10th April 2012

The Town and Country Planning Act 1990 (as amended)

Single storey pitch roof extension
53 Sunningdale Gardens Bognor Regis

Title
Plans as Proposed

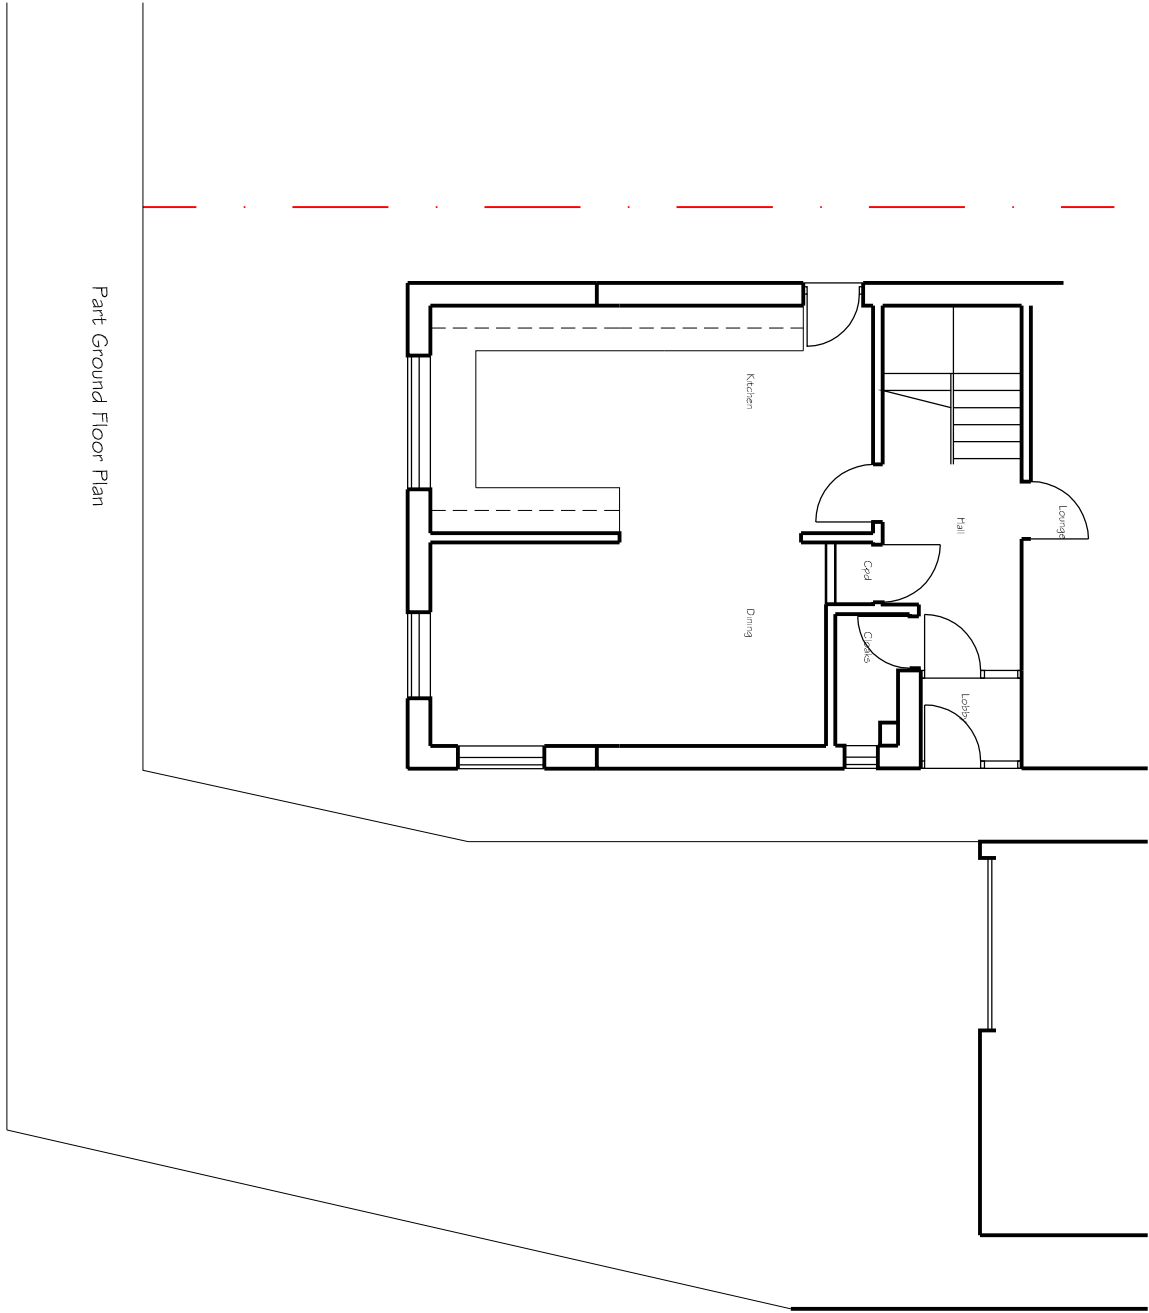
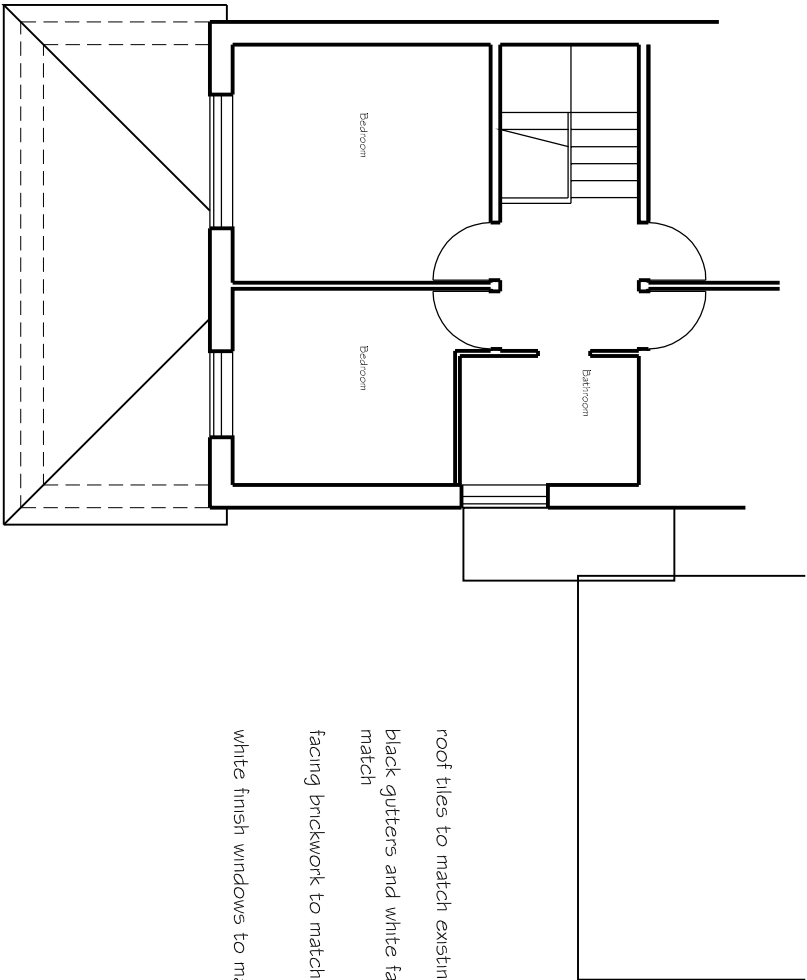
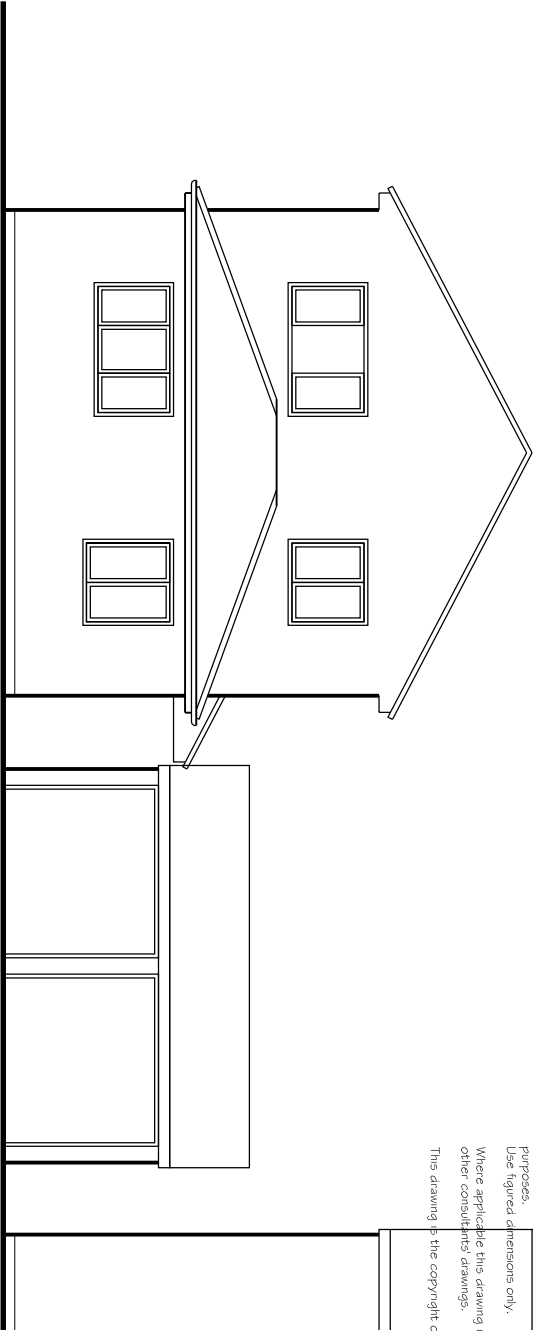
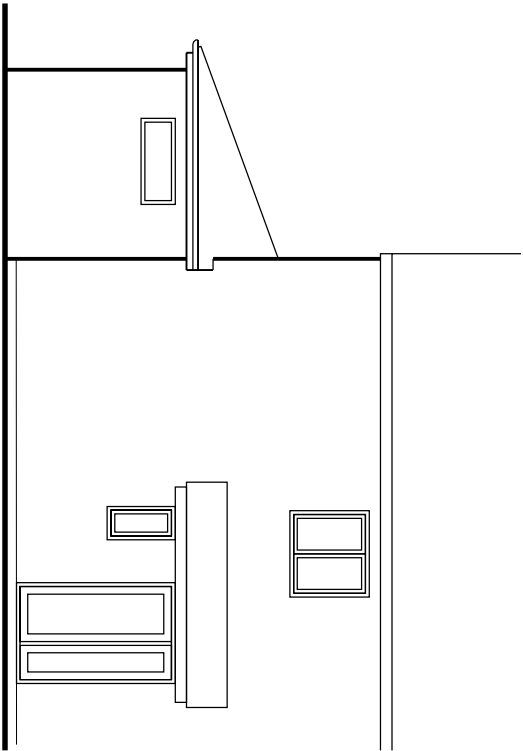
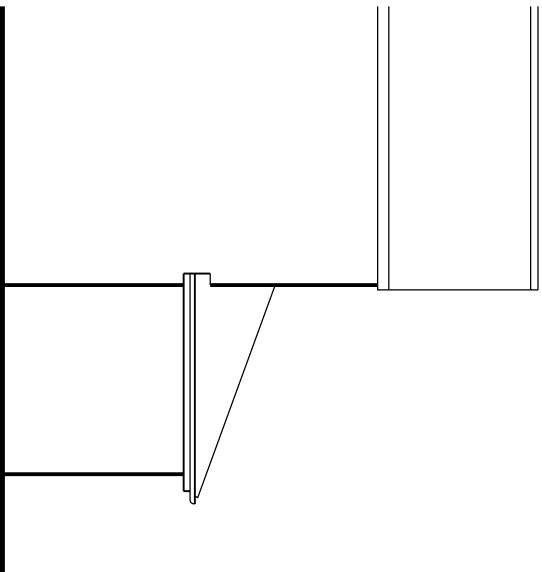
□
Firstly the proposed front ground floor extension to the front of the property is not in character with all other properties on the estate (sunningdale gardens). For those properties on the estate which have extended ground floor frontages these all consist of porch based extensions which extend out from the front of the properties to a maximum of approximately 4/5 feet and do not extend along the whole of the length of the front of the property. This application does not follow the same principles and instead consists of a total ground floor extension covering the whole width of the front of the property which will extended far beyond the present frontages afforded to any other property on the estate. The plans do not specifically say how far but I could envisage the extension coming out as far as 10/12 feet from the front of the property. □

□
My second concern is the roof of the proposed extension which again is not in character with any other properties in the estate. The application proposes a pyramid style roof. Whereas, all properties on the estate which currently have single floor front (porch) extensions added to the front of their properties all have sloping roofs from top back to bottom front. The plans for the roof of the proposed extension do not follow this long established principle which has applied to all other properties on the estate. Even the stand alone garages all have " A frame " style roofs as opposed to a pyramid type roof. □
